COUNTY OF HARNETT LAND USE APPLICATION

PROPERTY LOCATION. SR #: Hwy 24 SR Name: Hwy. 24
Parcel: 09-95750160 - 56 PIN: 9575-14-5576 5323
Zoning: RA-20R Subdivision: Nature's Crossroads - Phase II Lot #: 59 Lot Size: .62
Flood Plain: No Panel: 150 Watershed: No Deed Book/Page: 1593/64 Plat Book/Page: 2007/186

Re: Status of Improvement Permit Application #07-5-17048
Nature's Crossroads Lt 59

SURVEY FOR:
PINE GROVE DEVELOPMENT CORP.
LOT #59
NATURES CROSSROADS, PHASE TWO
0.62 ACRES

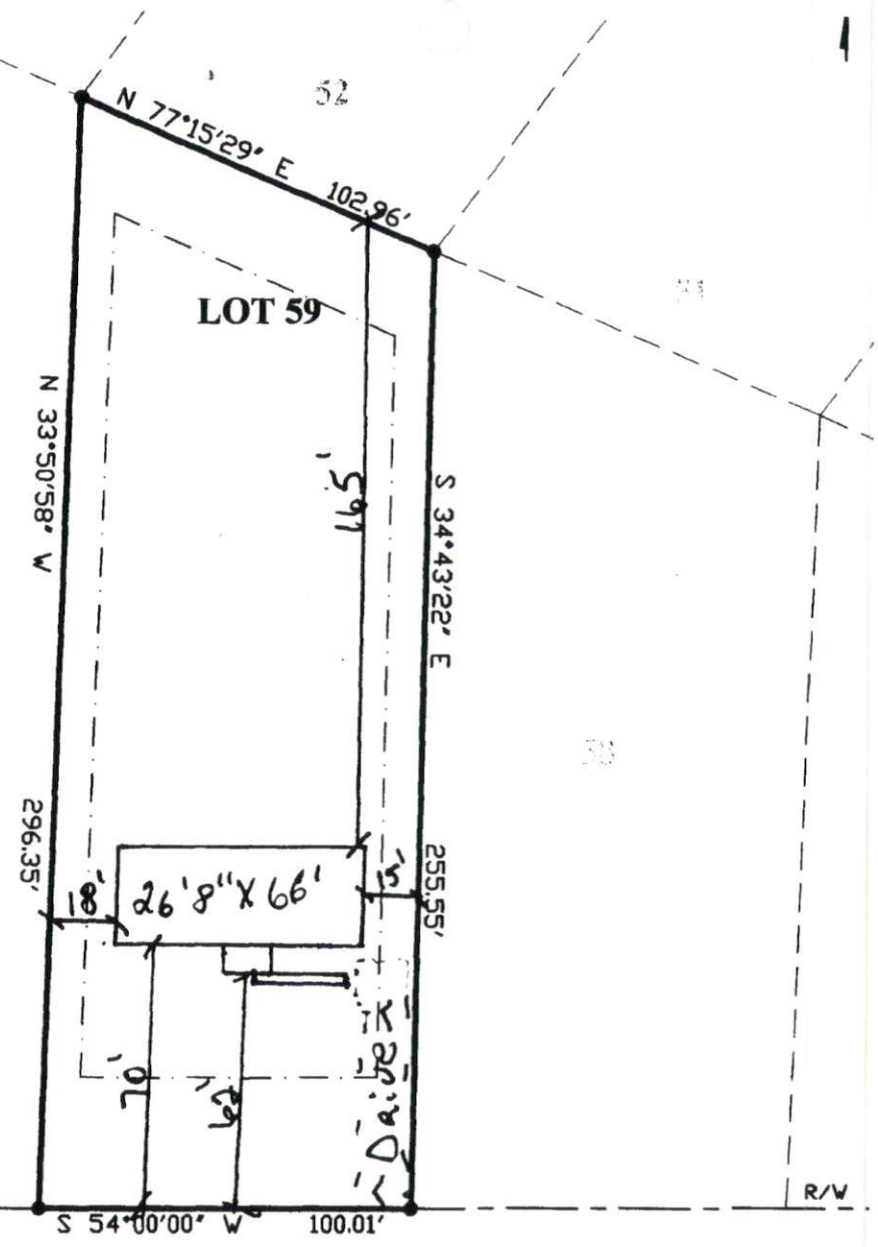
- 1. Property lines/corners not marked or labeled
- 2. House corners not marked or labeled
- 3. Directions not clear to property
- 4. Property needs brush or vegetation removed
- 5. Backhoe pits required
- 6. Other - Move house as shown (see attached sheet). Submit new plot plan to Central Permitting.
